Submission to mixed Use Development 26-30 Campsie Street & 1 Assets Street, Campsie Pre-lodgement (SSD- 99727456)

**Canterbury-Bankstown Council Submission
23 July 2026**

Figure 30. Ground Level Plan

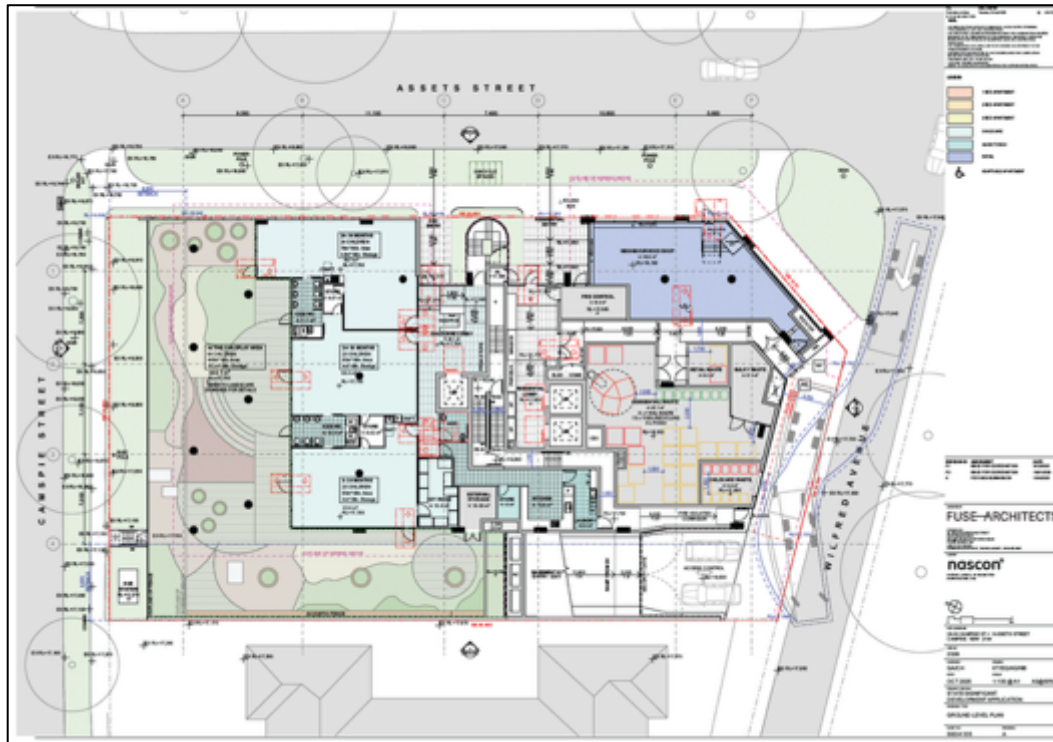
The absence of setbacks limits opportunities for meaningful landscaping, private open space, and a softened transition between the building and the public domain. Council notes in the adopted draft Campsie Town Centre DCP, the site is required to provide a 6m setback to Campsie Street, Assets Street and Wilfred Avenue. See Figure 1.

The proposed residential entry is located adjacent to the childcare entry on Assets Street and is positioned between the childcare facility and retail tenancy. As a result, the residential entry lacks prominence within the streetscape and does not clearly present as the primary address of a 16-storey residential building.

Given the site's primary frontage to Campsie Street, concerns remain that the proposed arrangement diminishes the legibility and identity of the residential component of the development.

The co-location of the residential and childcare entries also has the potential to create pedestrian congestion and user conflict during childcare drop-off and pick-up periods when the highest volumes of movement are expected to occur. This may adversely affect residential amenity, entry functionality and overall user experience.

- A minimum 3m – 6m setback should be provided along Assets Street to allow for adequate landscaping and private open space, improving public domain amenity and reinforcing the residential character of the street.

- The ground floor layout should be revised to provide a more prominent and clearly identifiable residential entry and minimise potential conflict between residential and childcare users.
